KITTITAS COUNTY COMMUNITY DEVELOPMENT SERVICES

August 21, 2008

RE: Kohl Short Plat (SP-08-00017)

Kittitas County Community Development Services Department has determined that the Kohl Short Plat (SP-08-17) is a complete application and hereby grants **conditional preliminary approval** subject to the following conditions:

KOHL SHORT PLAT
Portion NW 1/4, Sec. 5, T.19N., R.15E., W.M.
Kittitas County, Washington

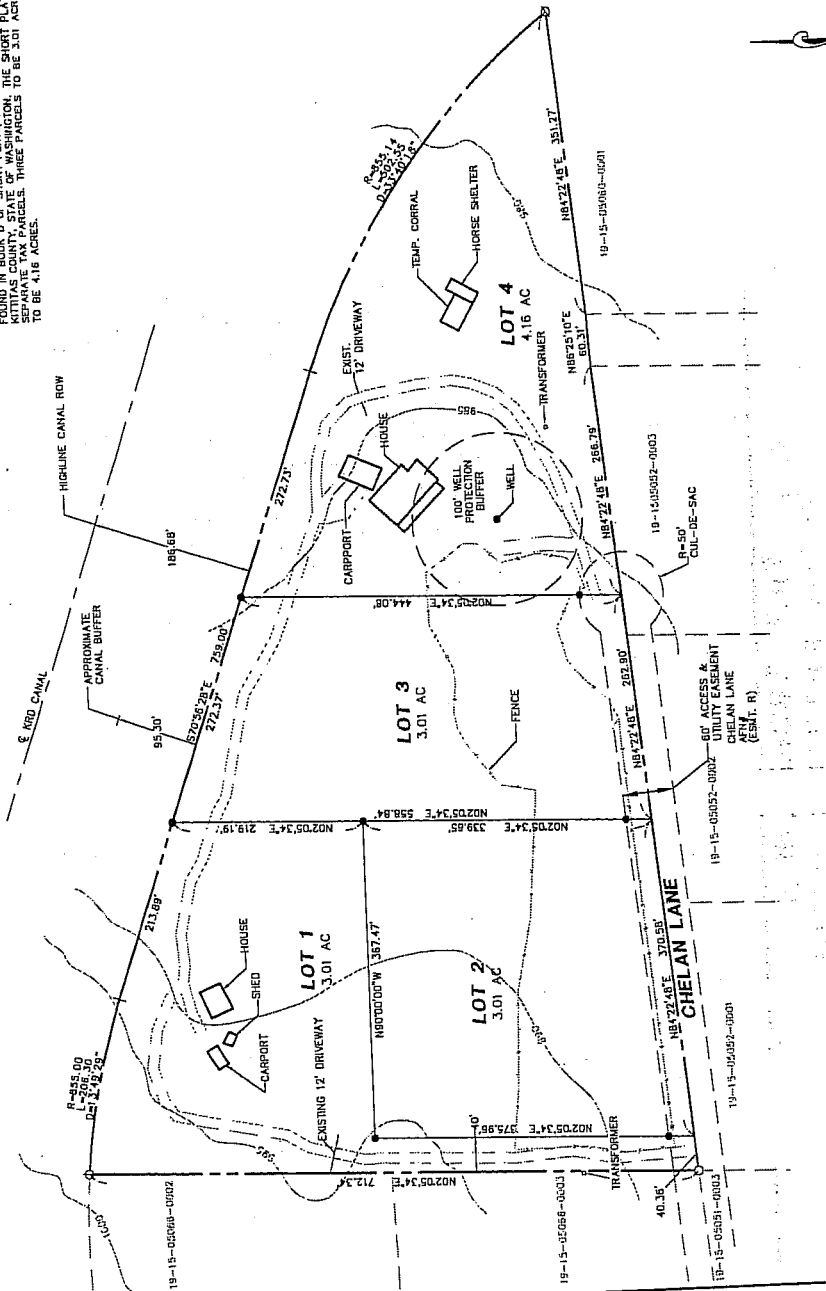
1. Both sheets of the final mylars shall reflect short plat number SP-08-00017 and an accurate legal description shall be shown on the face of the final plat.

2. Full year's taxes shall be paid for on all tax parcel numbers per requirement of the Kittitas County Treasurer's Office.
3. Because the applicant has decided to utilize individual wells rather than a "Group B" system as previously discussed, all references to a "Group B" water system shall be removed from the final mylars and replaced with reference to individual wells.

5. **The following plat notes shall be recorded on the final mylar drawings:**
 - All development must comply with International Fire Code.
 - The subject property is within or near existing agricultural or other natural resource areas on which a variety of activities may occur that are not compatible with residential development for certain periods of varying duration. Agricultural or other natural resource activities performance in accordance with county, state and federal laws are not subject to legal action as public nuisances. Kittitas County has adopted the right to farm provisions contained in Section 17.74 of the Kittitas County Zoning Code.

- Per Kittitas County Code 16.18.060, only sprinkler or drip irrigation is allowed for lots 3 acres or less in size.
 - All lots shall share a single ground water withdrawal of no more than 5,000 gallons per day which may be accomplished by more than one well. No more than ½ acre of lawn and garden shall be irrigated

- The approval of this division of land includes no guarantee that there is a legal right to withdraw groundwater within the land division. The approval of this division of land provides no guarantee that use of water under the ground water exemption (RCW 90.44.050) for this plat or any portion thereof will not be subject to curtailment by the Department of Ecology or a court of law.

- Metering will be required on all residential well connections and metering results shall be recorded in a manner consistent with Kittitas County and Washington State Department of Ecology requirements.
